Our ref: HA/2022/124003/02-L01
Your ref: FP/274/21/OUT

AMENDED PLANS - OUTLINE PLANNING APPLICATION WITH ALL MATTERS RESERVED, EXCEPT MEANS OF ACCESS, FOR THE ERECTION OF UP TO 480 NEW HOMES (C3), THE FORMATION OF A NEW MEANS OF ACCESS ONTO GOLF LINKS ROAD, TOGETHER WITH THE CREATION OF NEW SURFACE WATER DRAINAGE, NEW LANDSCAPING AND HABITAT CREATION, GROUND WORKS AND OTHER INFRASTRUCTURE AND THE RETENTION AND RE-PURPOSING OF THE RETAINED CLUB HOUSE (F2). THIS SITE ALSO LIES WITHIN THE PARISH OF YAPTON, AFFECTS A PUBLIC RIGHT OF WAY AND IS A DEPARTURE FROM THE DEVELOPMENT PLAN. THIS APPLICATION IS SUBJECT TO AN ENVIRONMENTAL STATEMENT.

BOGNOR REGIS GOLF CLUB, DOWNVIEW ROAD, FELPHAM, PO22 8JD.

EARTHWORKS ANALYSIS

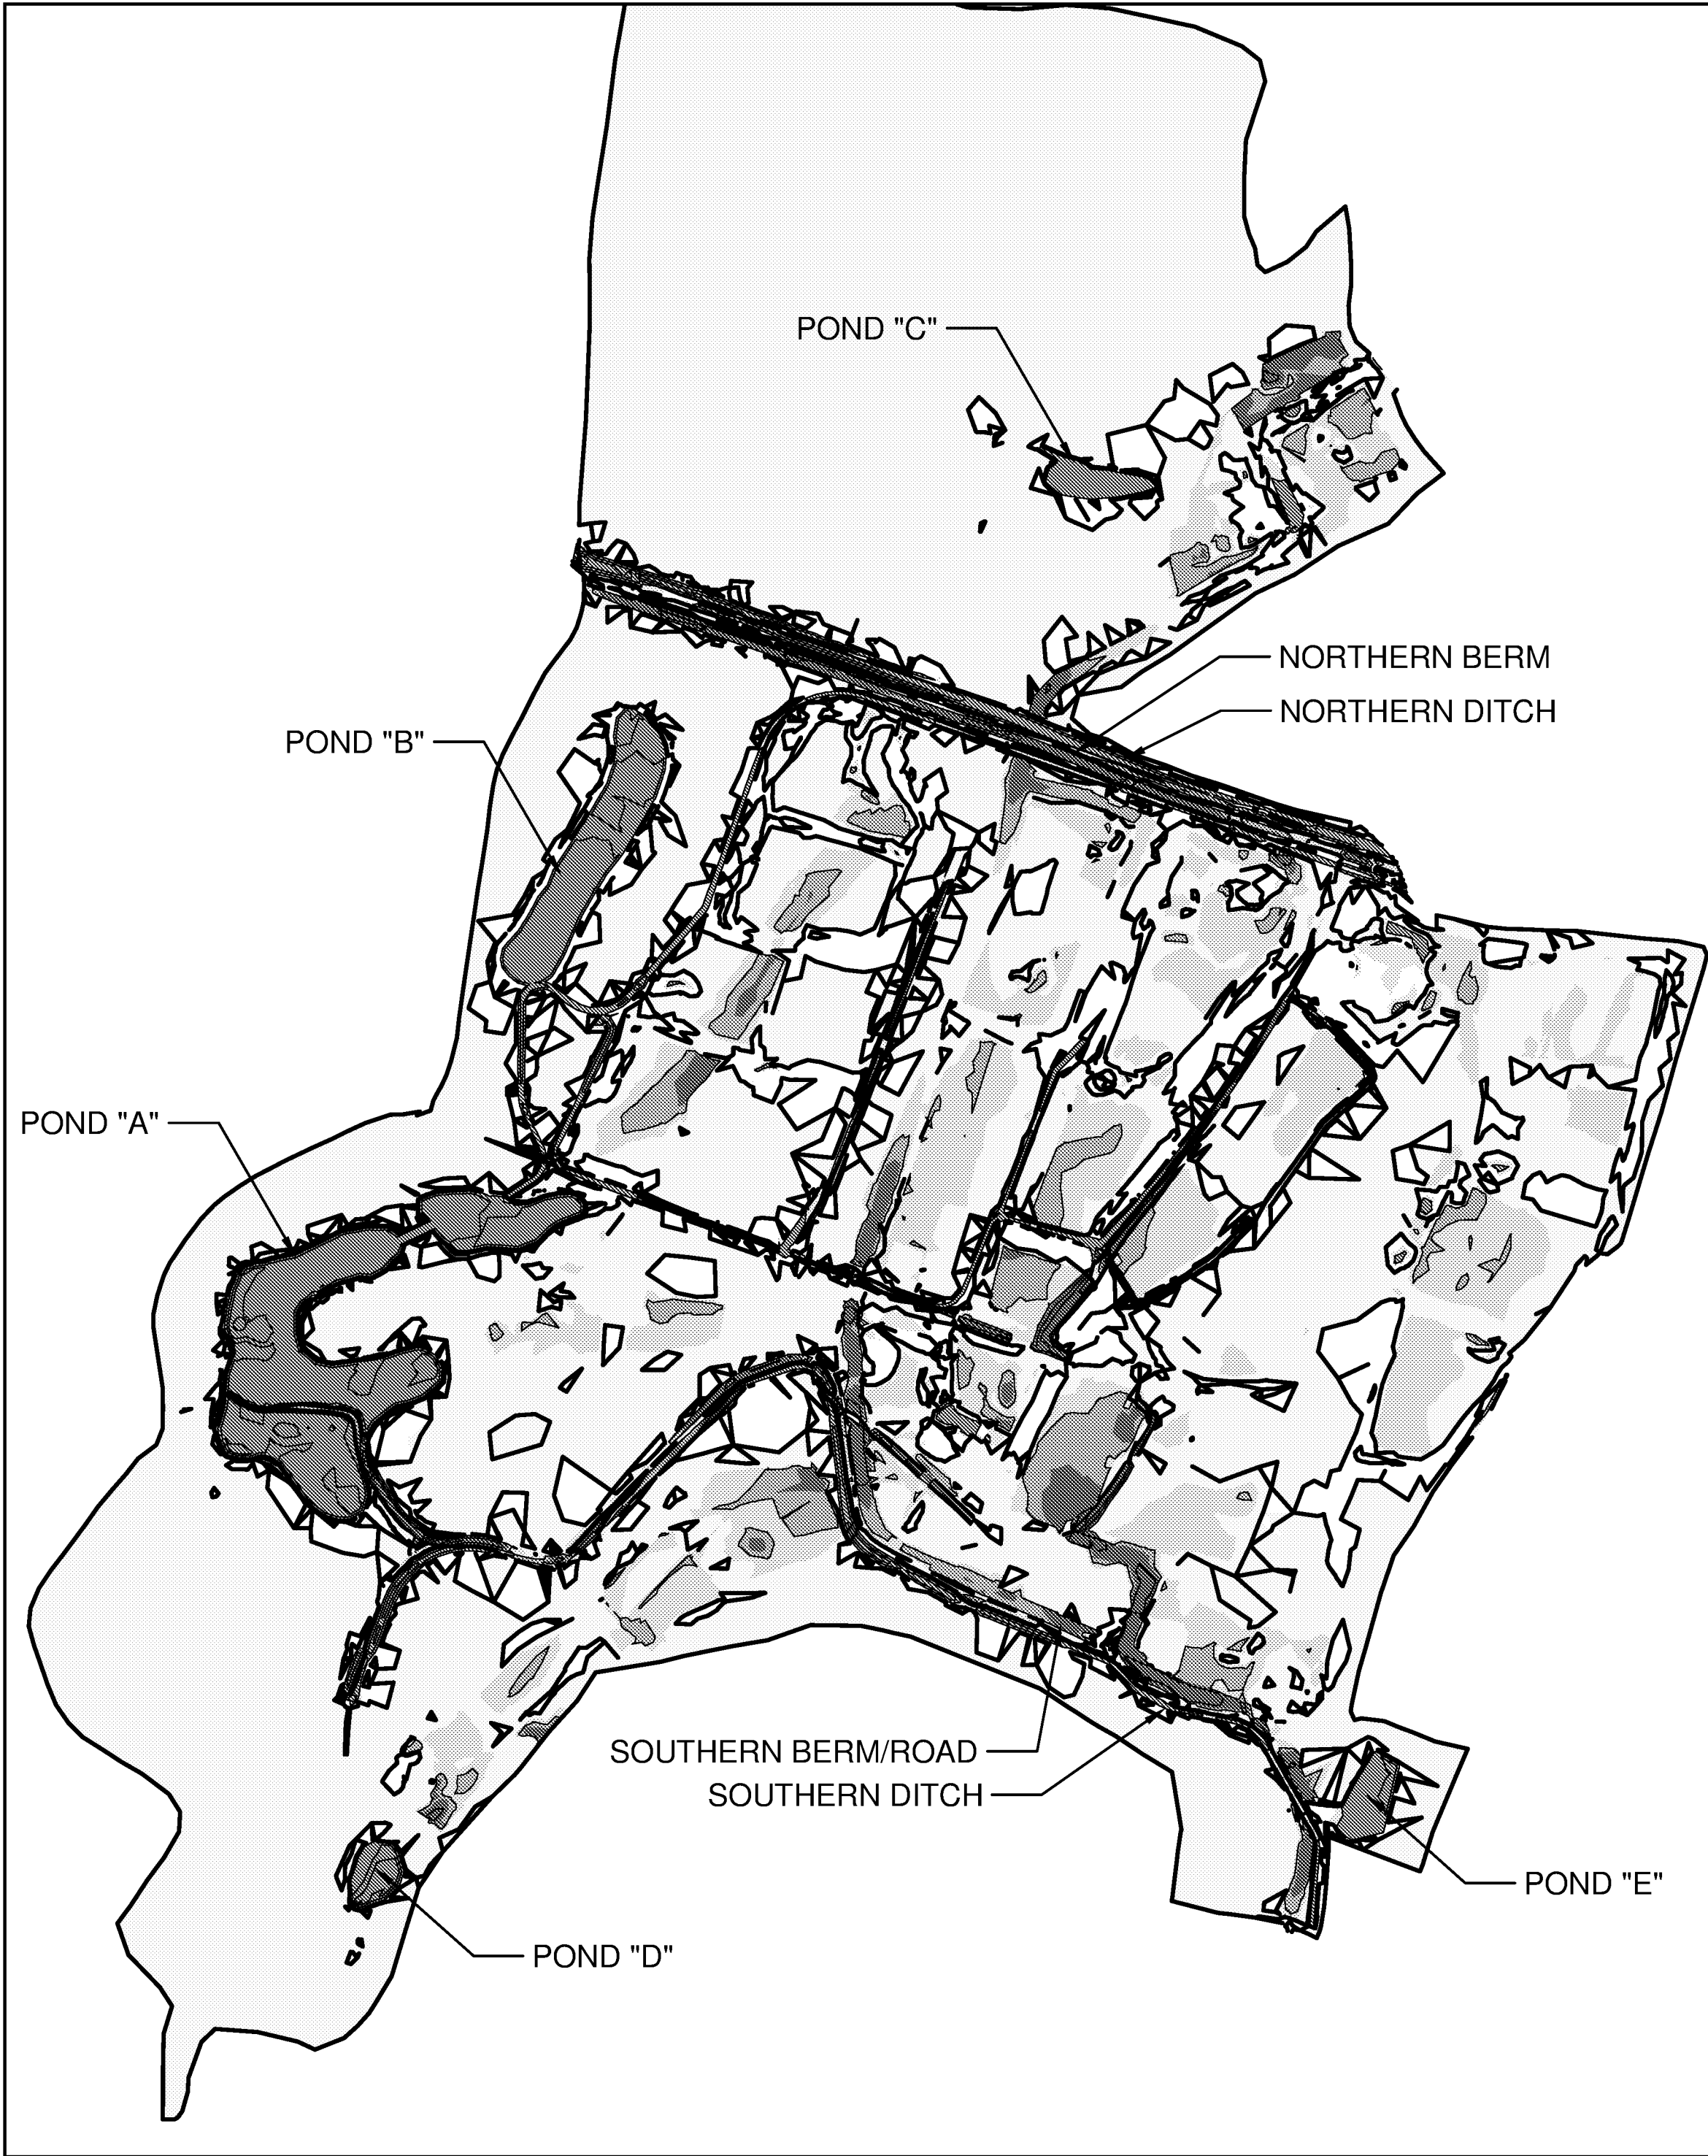
- Drawings showing any changes to ground levels post development.
- Baseline and post-development model outputs in GIS format.

To overcome our objection, the applicant should submit a revised FRA which addresses the points highlighted above.
